Transport
for NSW

**NORTH PENRITH DEFENCE SITE SUBDIVISION OF STAGE 3A (SSD 5348)
NOTICE OF EXHIBITION**

TRANSPORT FOR NSW TRANSPORT CLUSTER COMMENTS

NORTH PENRITH DEFENCE SITE SUBDIVISION OF STATE 3A (SSD 5348)

NORTH PENRITH  
STAGE 3A  
ROAD LAYOUT

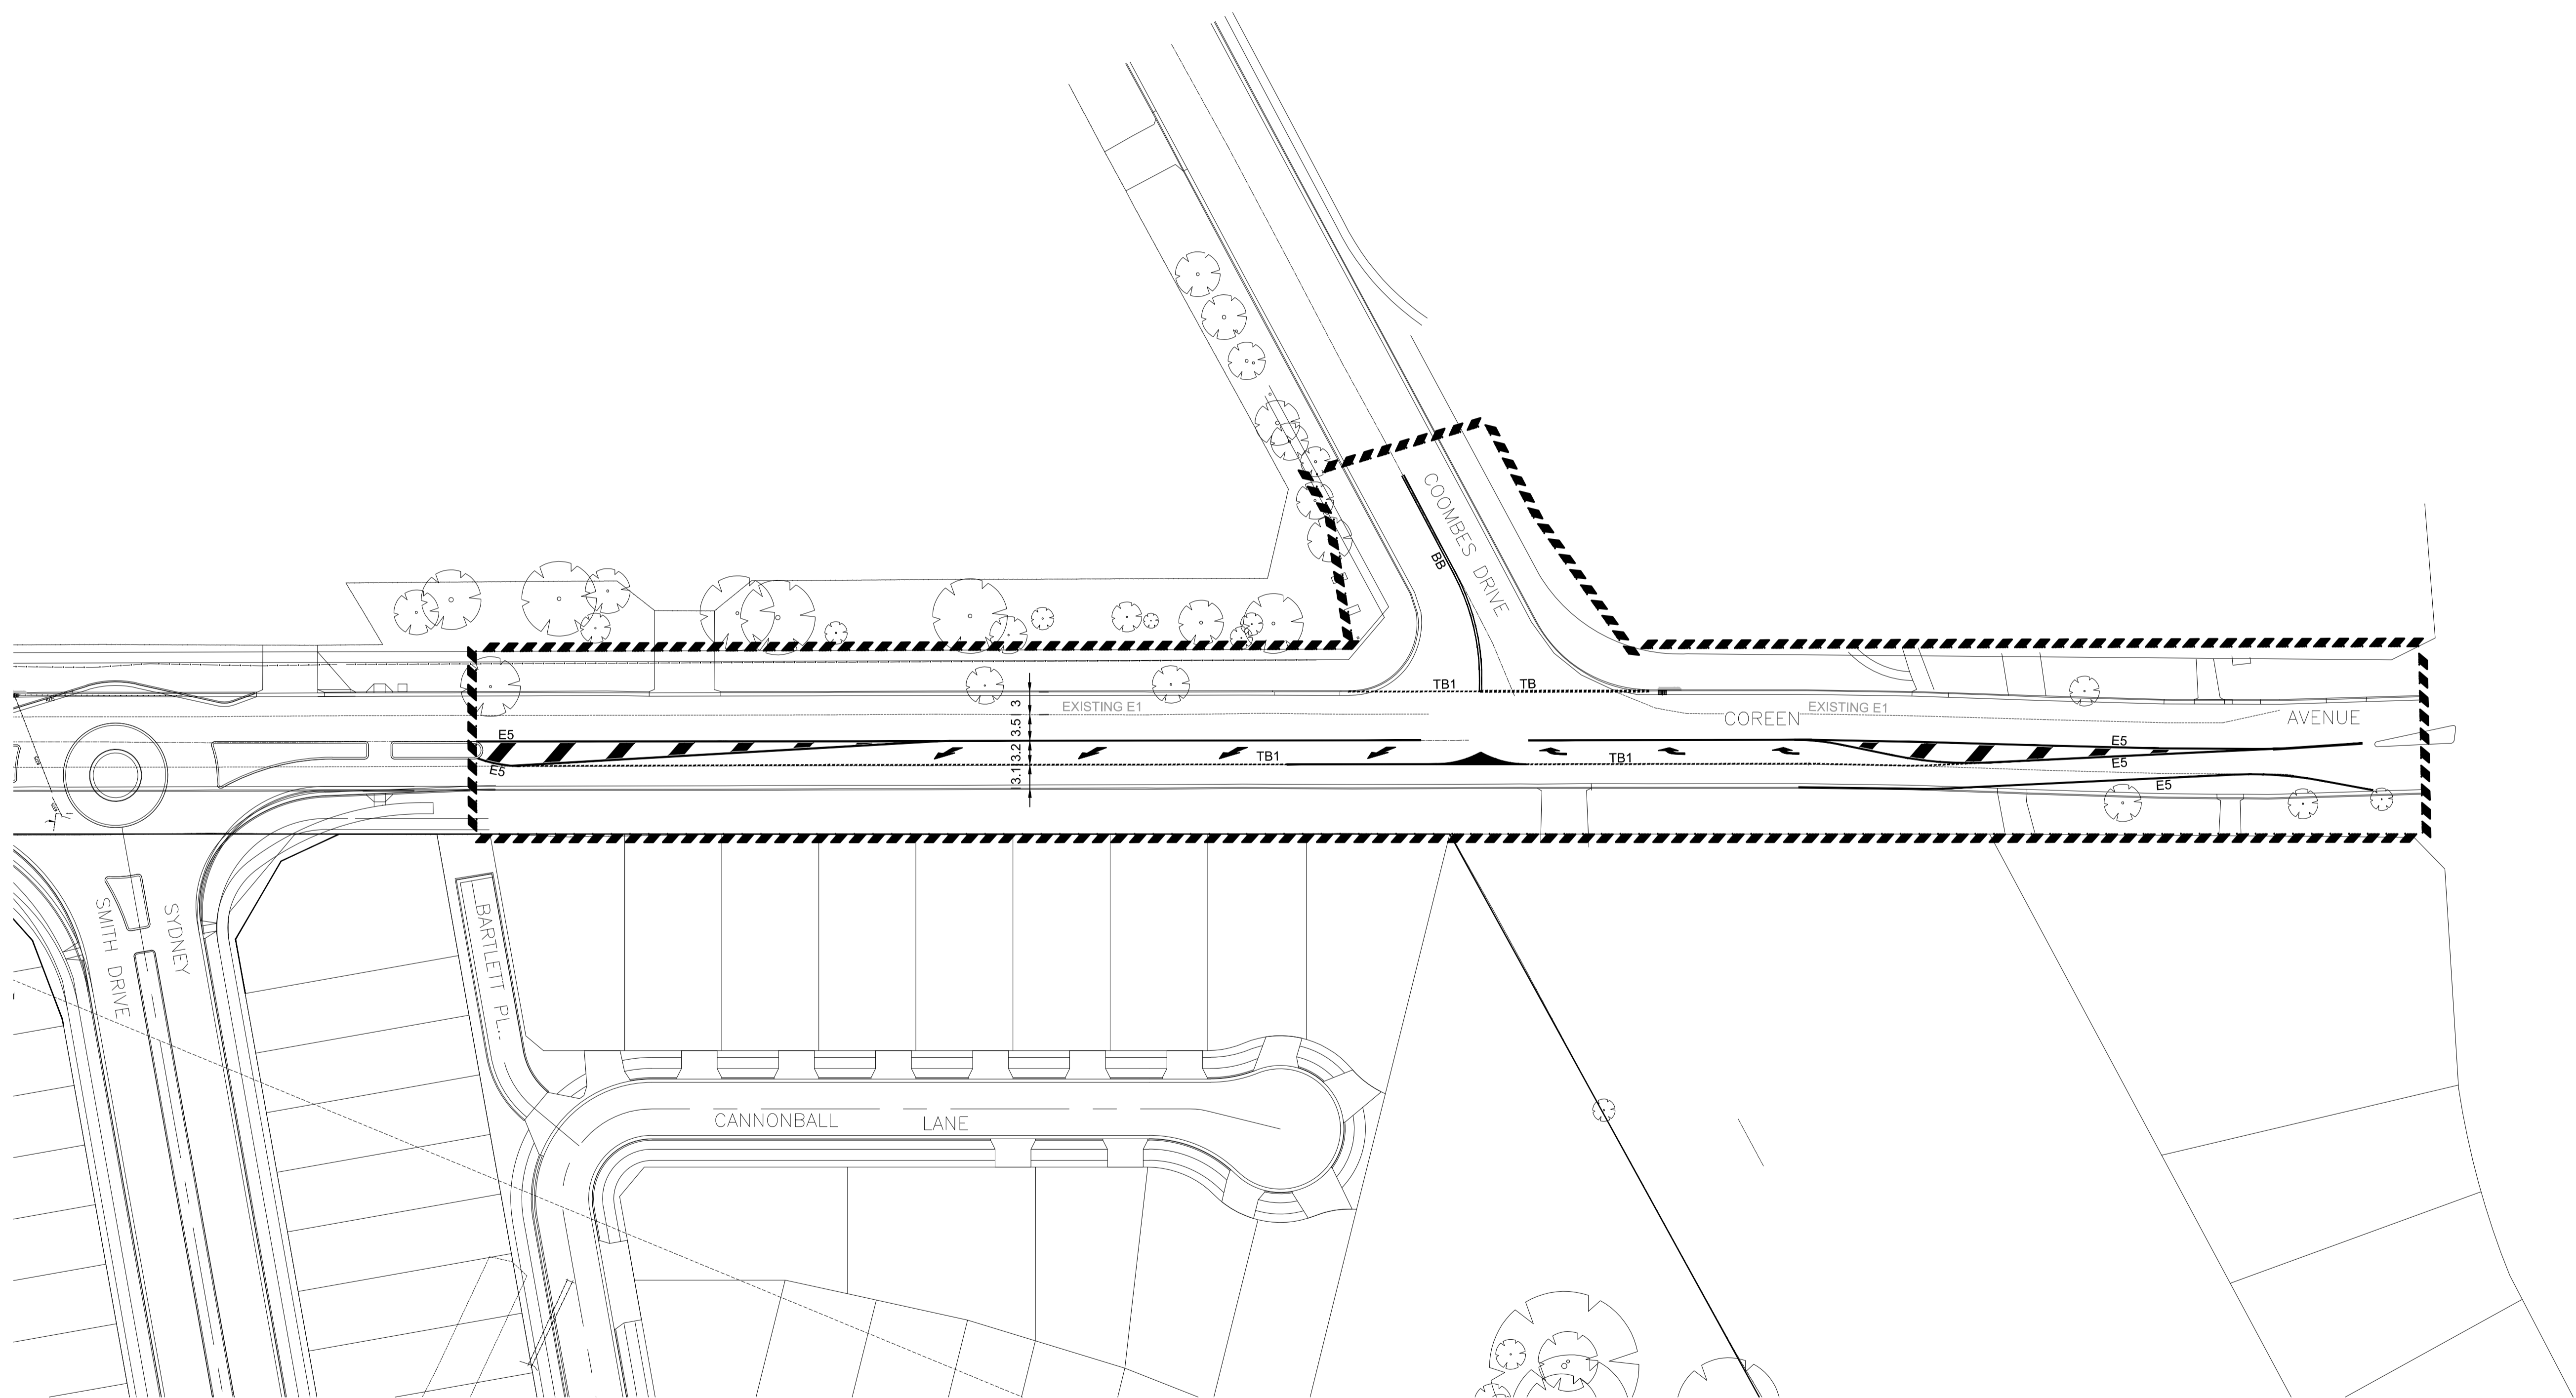
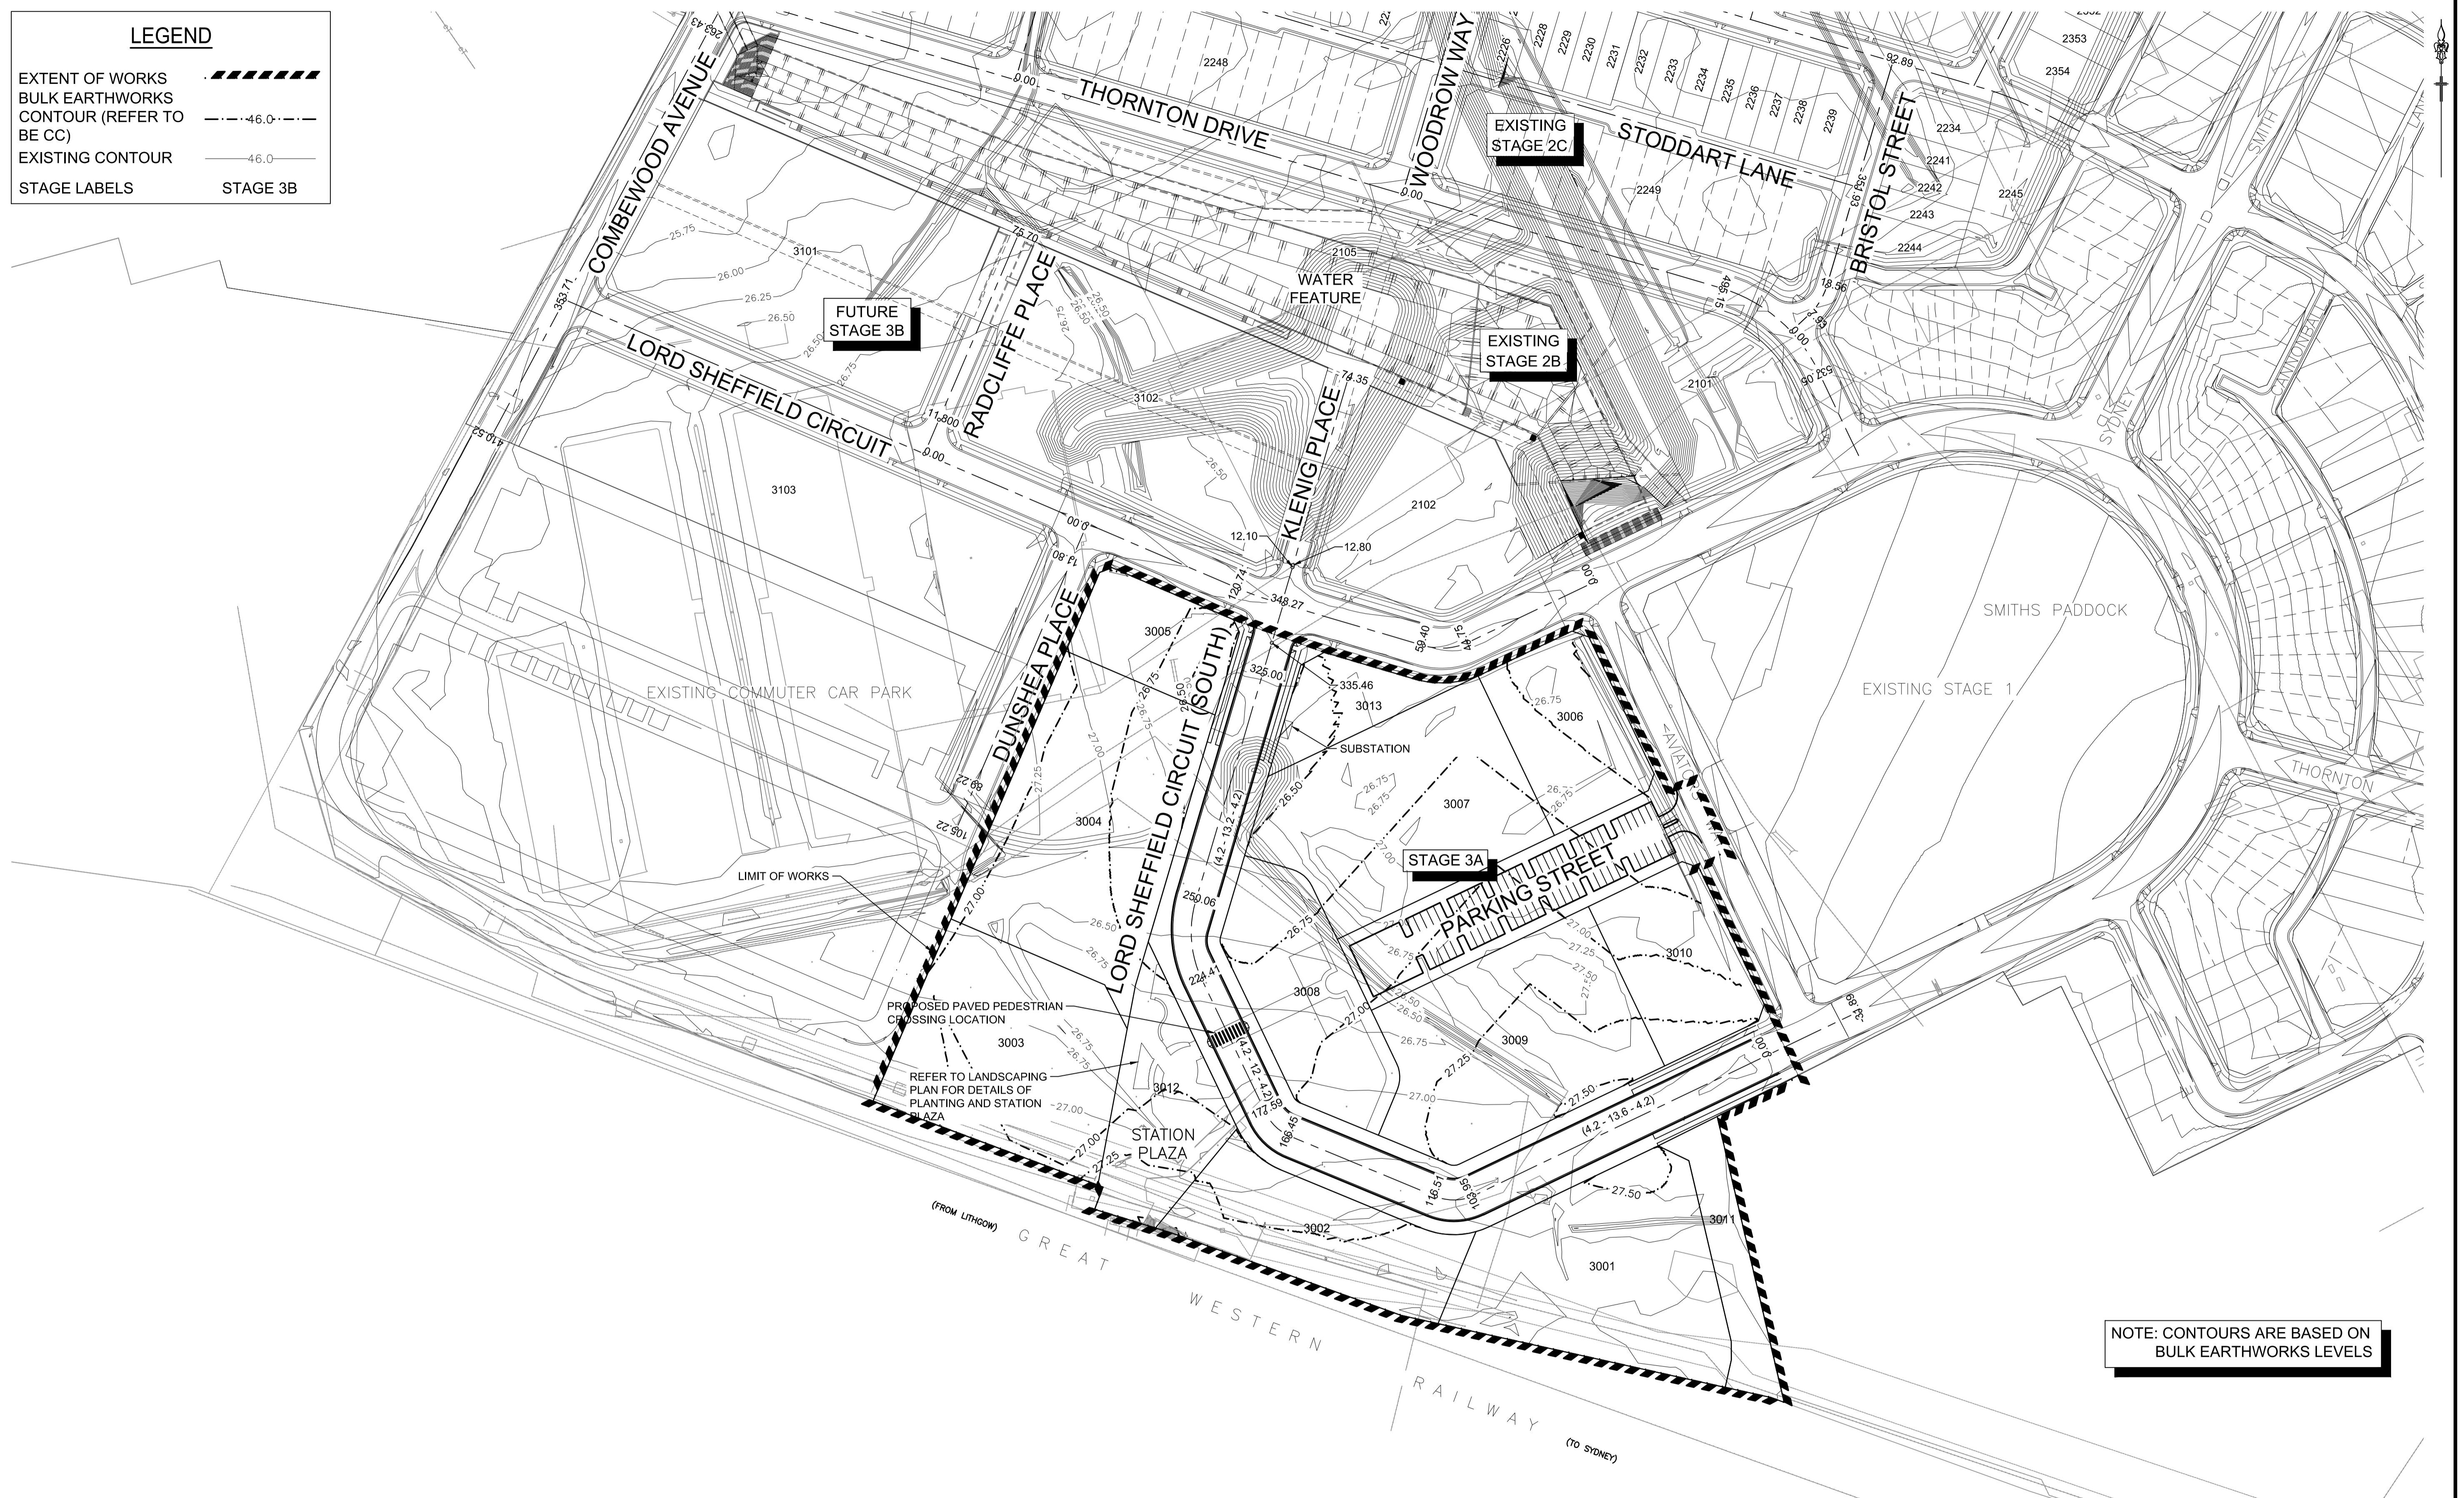
The diagram illustrated in **Attachment 2** was provided to the developer at this stage, and indicated the roads and intersections that should be considered. These particular roads at least should be designed to accommodate overall bus manoeuvrability, bidirectional movement and swept paths of buses up to 14.5 metres in length such that there is no centreline crossing.

TfNSW continues to require these amendments.

RailCorp does not support the approval of the subdivision plan (as lodged with the subject EIS) as it does not contain the registered easement and also does not comply with the Director-General Requirements which specifically state that the subdivision plan is to include all easements.

RailCorp was furnished with a revised subdivision plan (**Attachment 3**) which now includes the registered easements. RailCorp will support the approval of this plan, subject to DPI imposing the following condition:

- The subdivision plan shall not be registered until all easements burdening the subject land have been included and a written endorsement from RailCorp's land Information Unit has been obtained.
